# CITY OF ALBUQUERQUE

March 17, 2026

**RE: 300 Utah St NE  
Grading & Drainage Plan  
Engineer's Stamp Date: no stamp date  
Hydrology File: K19D160  
Case # HYDR-2026-00098**

ENGINEER'S SEAL MARCH 18, 2026 ROGER MARTINEZ P.E. #17871	LOTS 1-4, BLOCK 21 MESA VERDE ADDITION 304 UTAH STREET NE	DRAWN BY: MM DATE: 3-17-2026
	GRADING & DRAINAGE PLAN	SHEET # C1
 PO Box 6636 ALBUQUERQUE, NM 87193 (505) 280-8314	JOB #

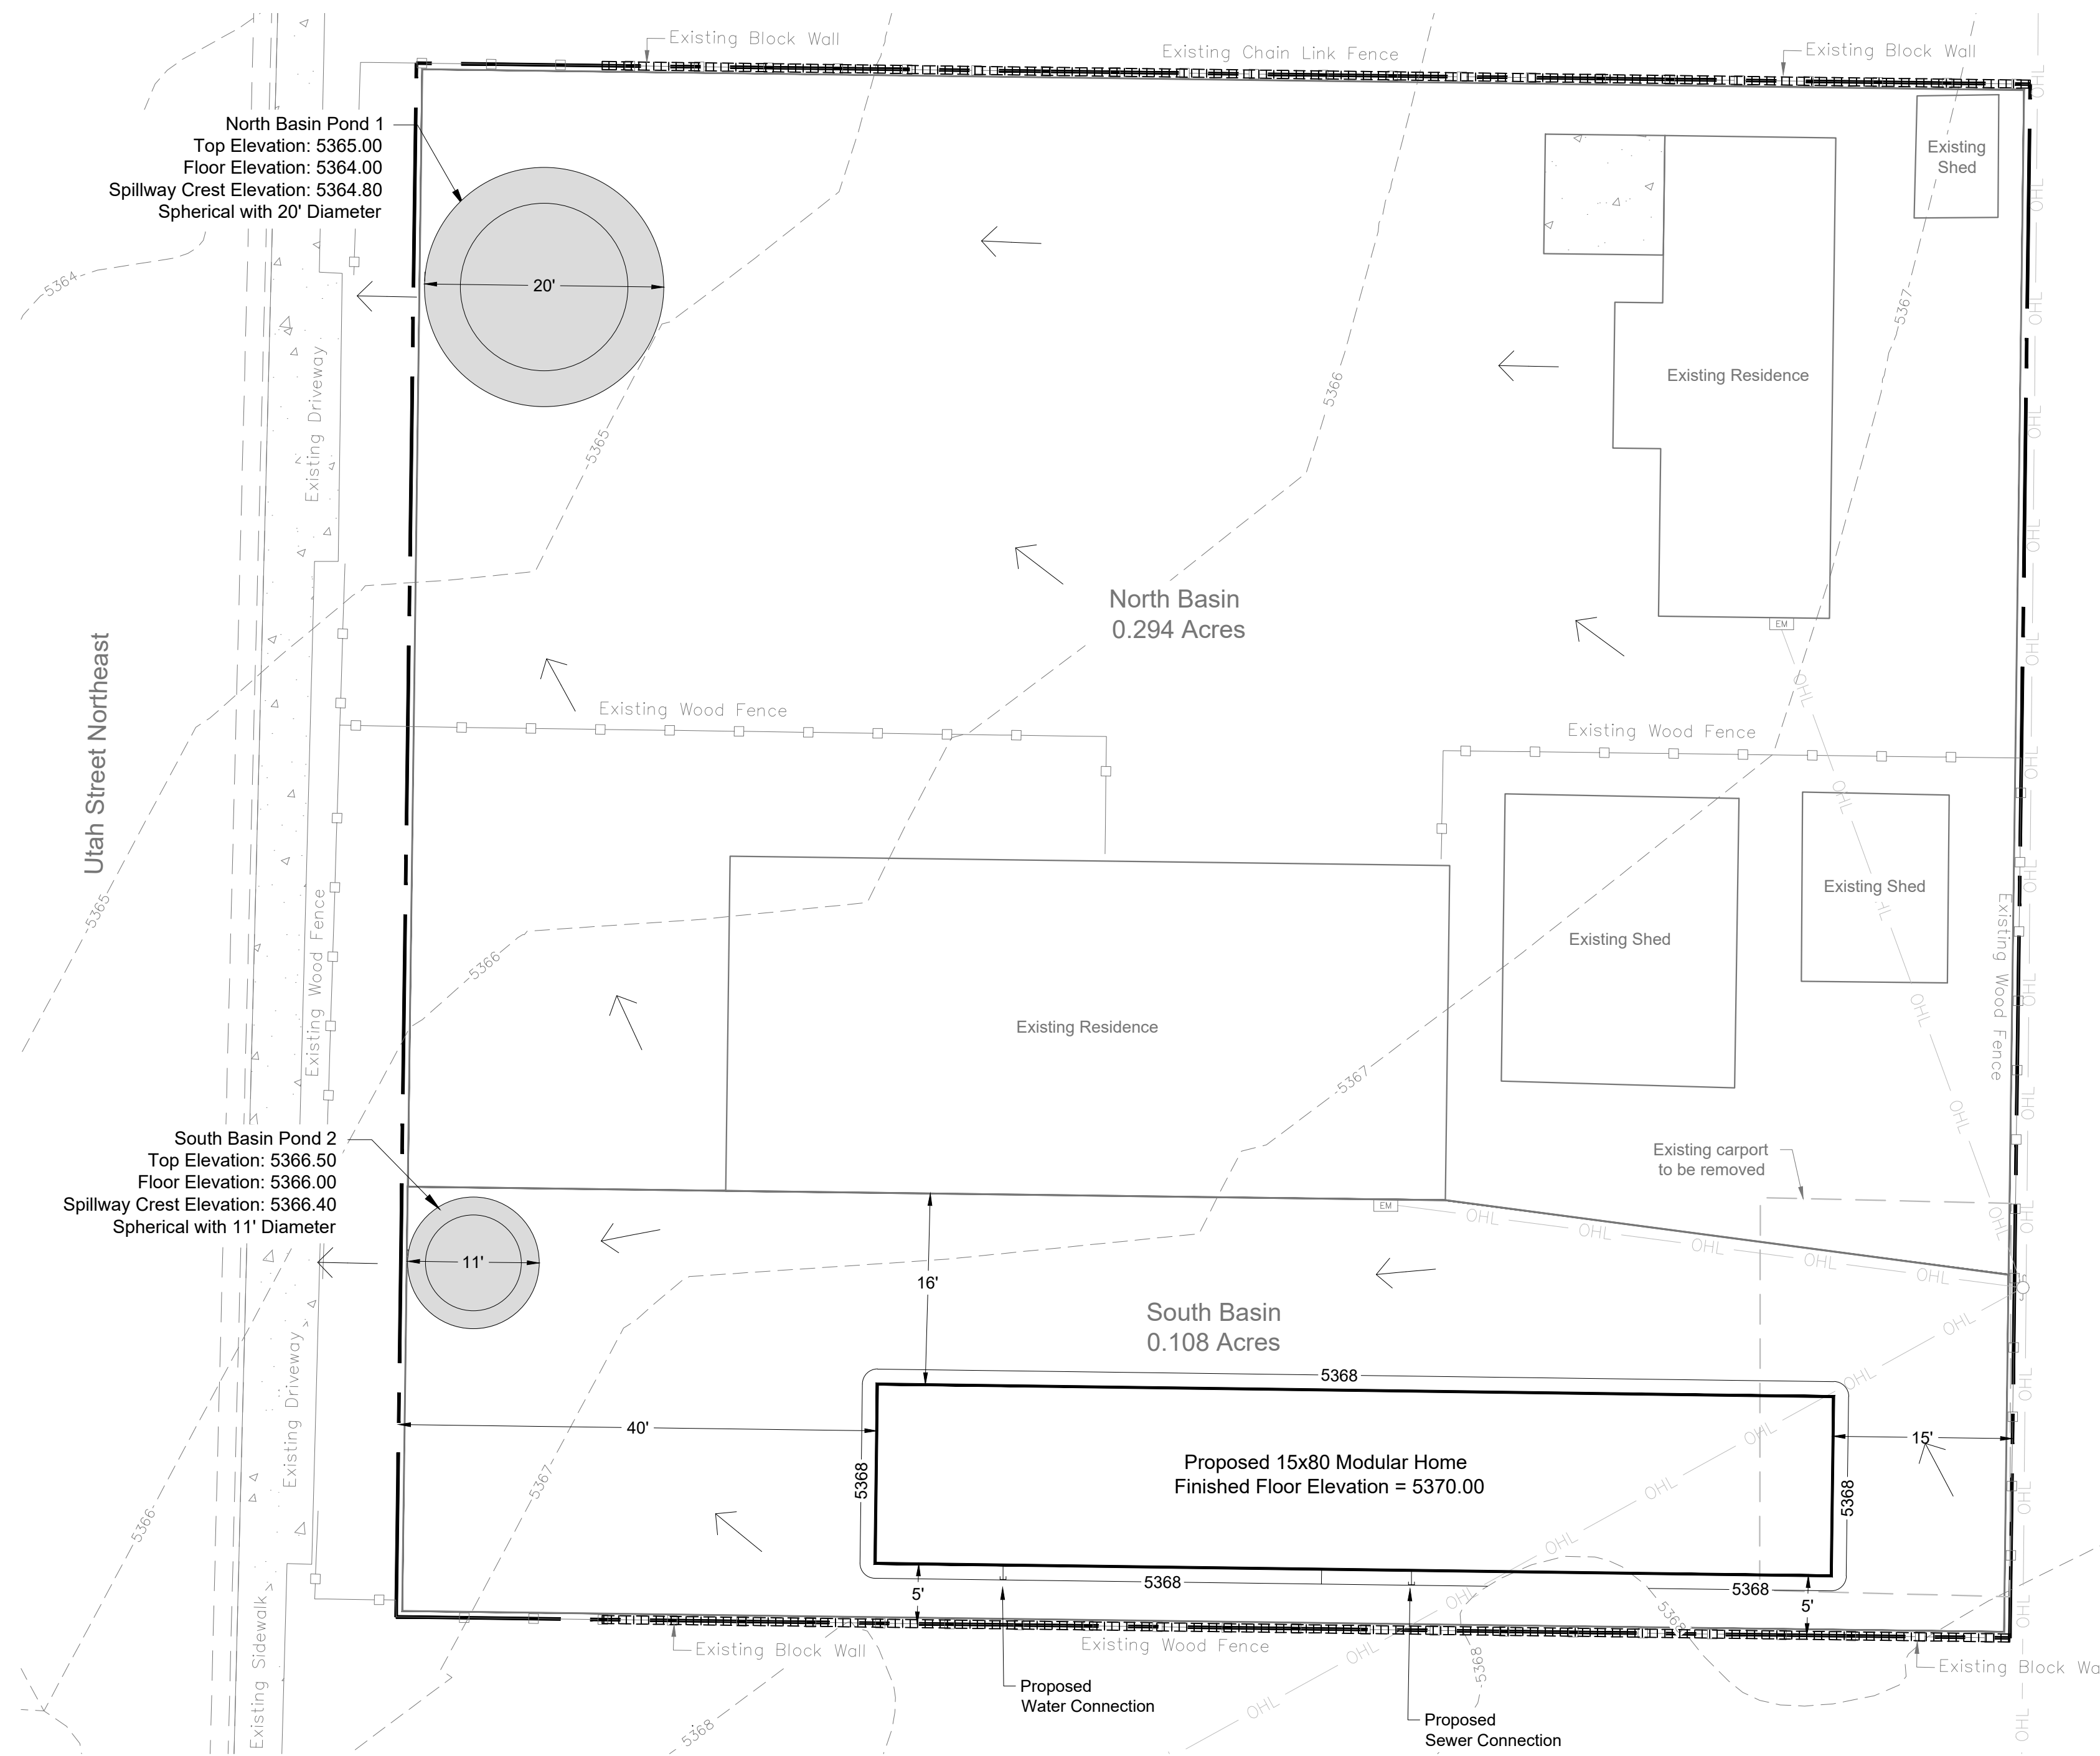
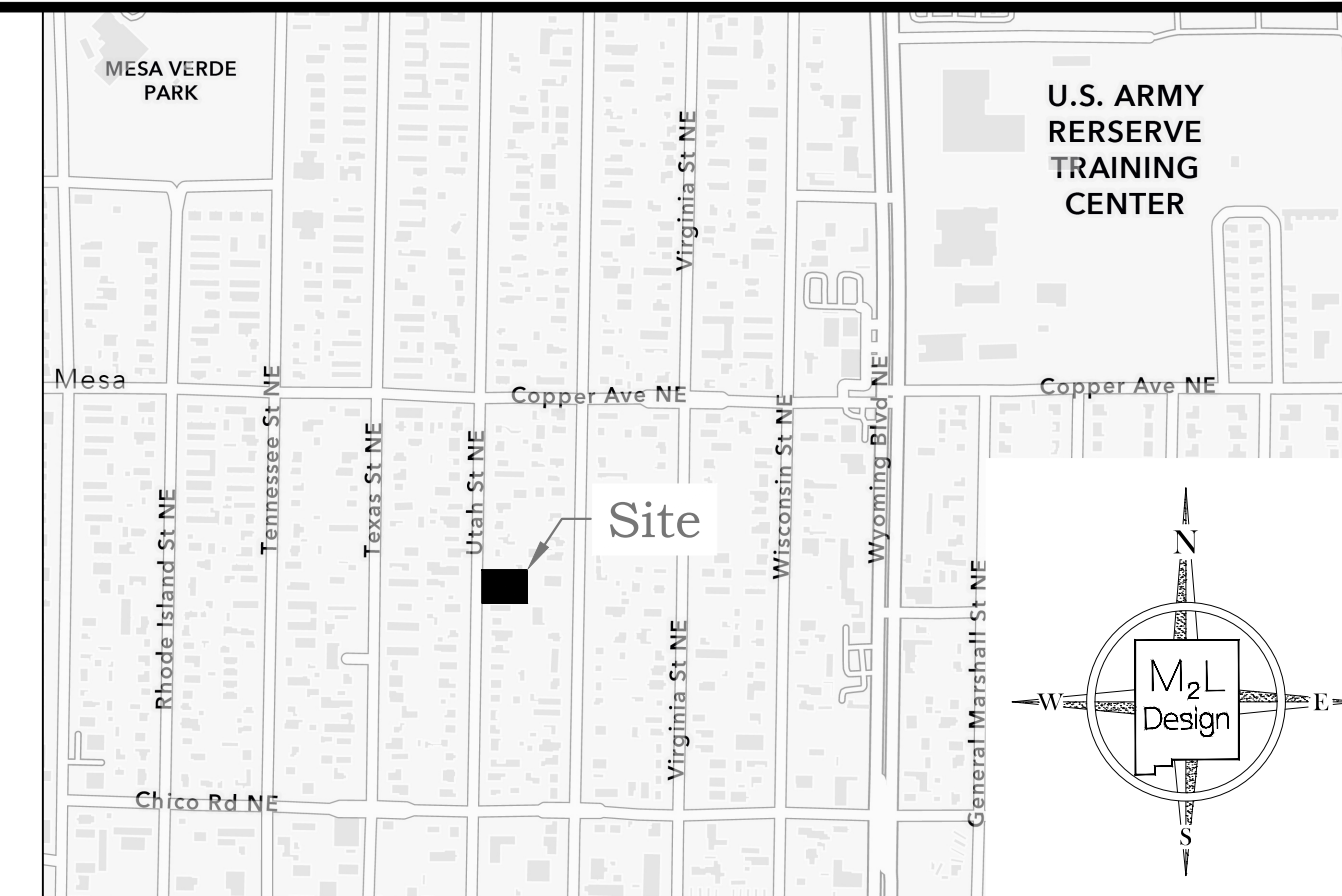
1. Please provide an engineer's stamp with a signature and date.
2. Please provide the Benchmark information (location, description and elevation) for the survey contour information provided.
3. Recalculate the Proposed line on the table. The area for existing and proposed needs to match. What is changing is the land treatment type given the new development. See example below:

Area (sf)	Area (ac)	Treat. A %	Aa acres	Treat. B %	Ab acres	Treat. C %	Ac acres	Treat. D %	Ad acres
existing	17550	0.403	0%	0.0000	0%	0.000	82%	0.330	18%	0.073
Proposed	17550	0.403	0%	0.0000	0%	0.000	75%	0.302	25%	0.101

4. Remove the line for SWQV-NEW as this is a re-development site.
